# CITY OF ALBUQUERQUE

**RE: Transport Housing Apartments  
2900 Transport St. SE  
Conceptual Grading & Drainage Plan  
Engineer's Stamp Date: 05/20/21  
Hydrology File: M15D023H**

Based upon the information provided in your submittal received 05/21/2021, the Conceptual Grading & Drainage Plan is **not** approved for action by the DRB on Preliminary Plat or Site Plan for Building Permit. The following comments need to be addressed for approval of the above referenced project:

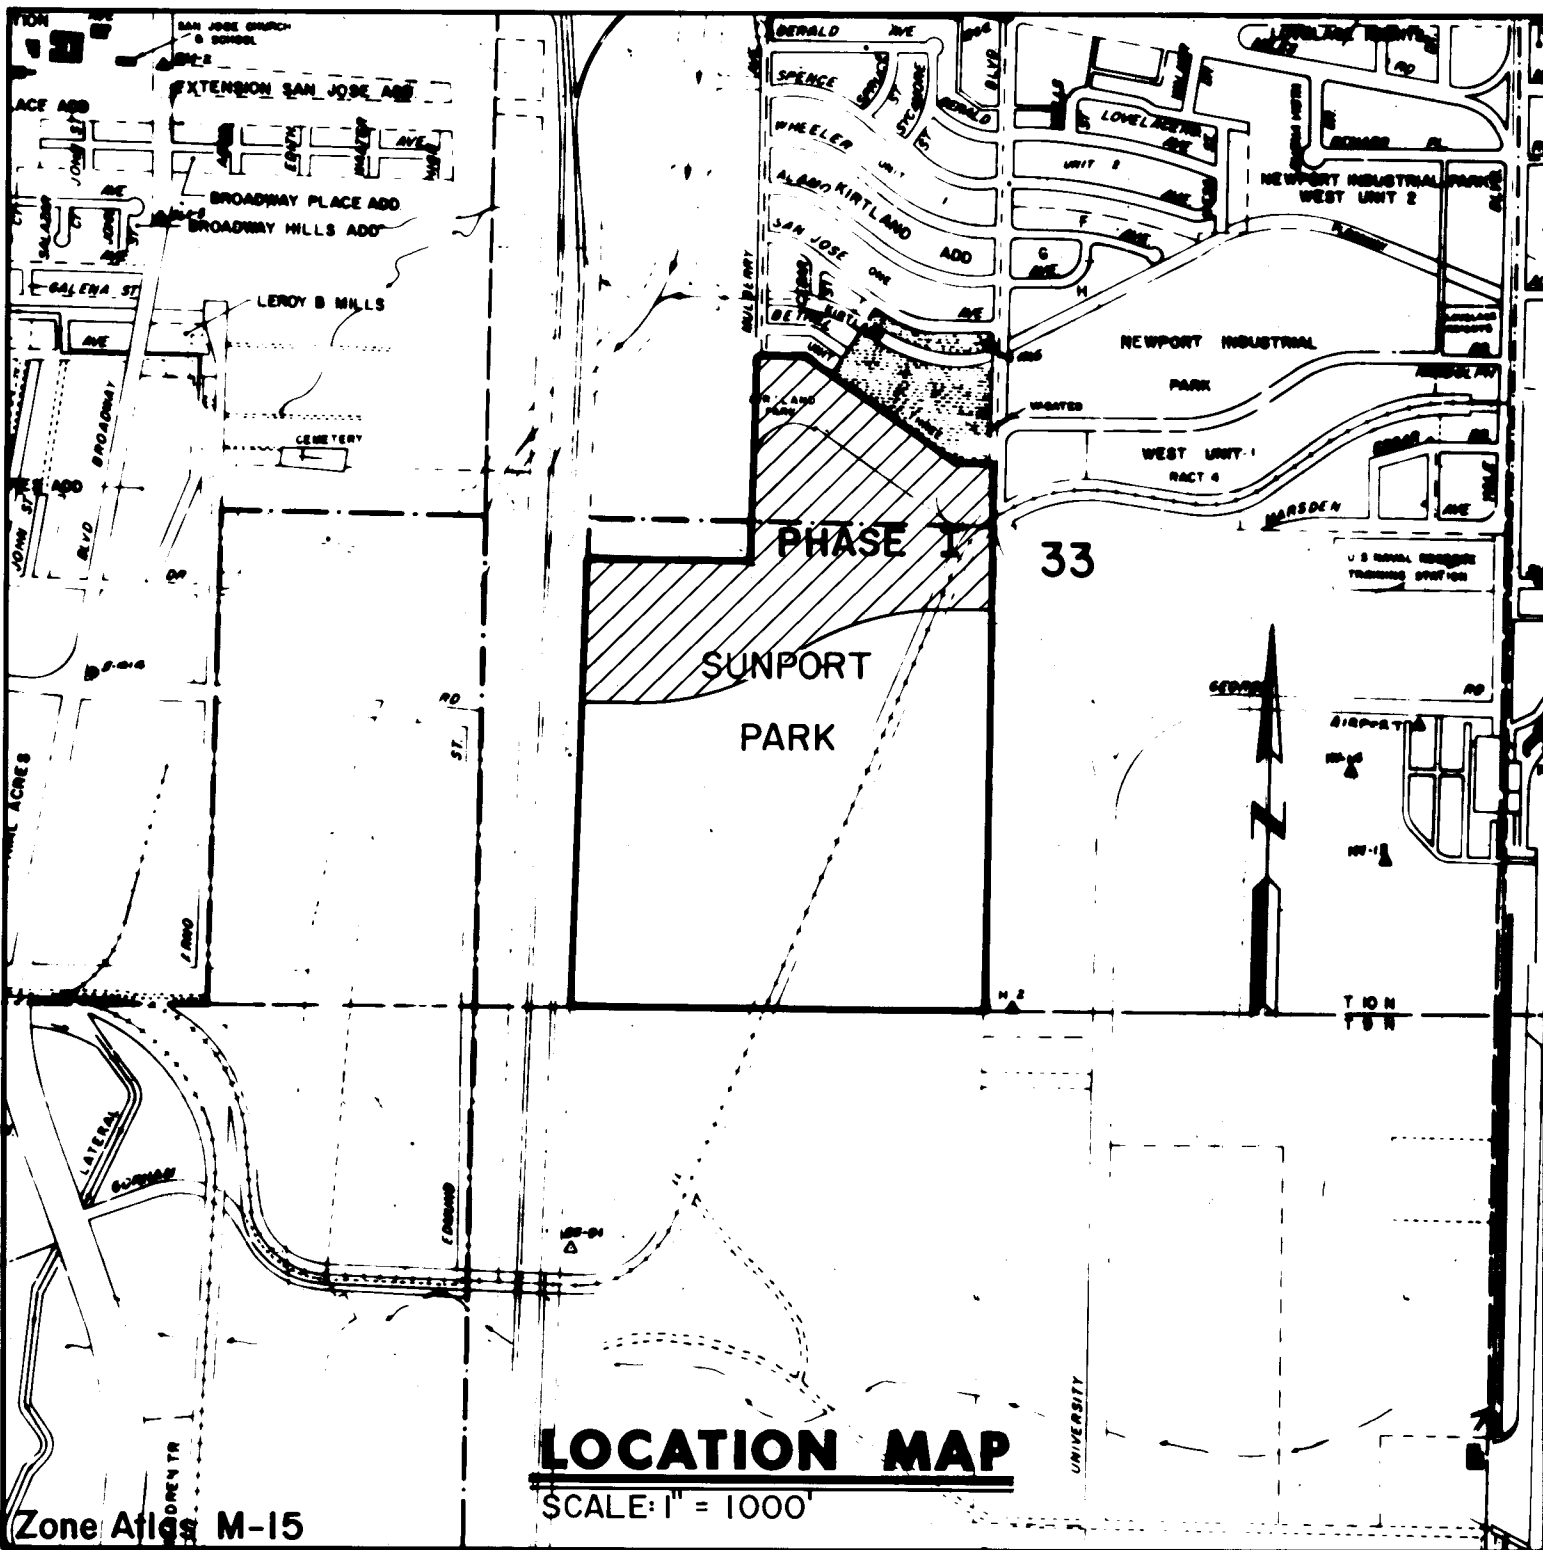
1. Sheet 2.2. Please add the existing Basins that correspond to Sunport Phase 1 Master Drainage Plan to both the existing and the proposed basins.

4. Sheet 2.2. Please add some drainage arrows on the proposed drainage basins showing how each area will drain to the respected detention pond.
5. Sheet 2.1 Please show maintenance ramps for each detention ponds. Also show a driveway for each pond.
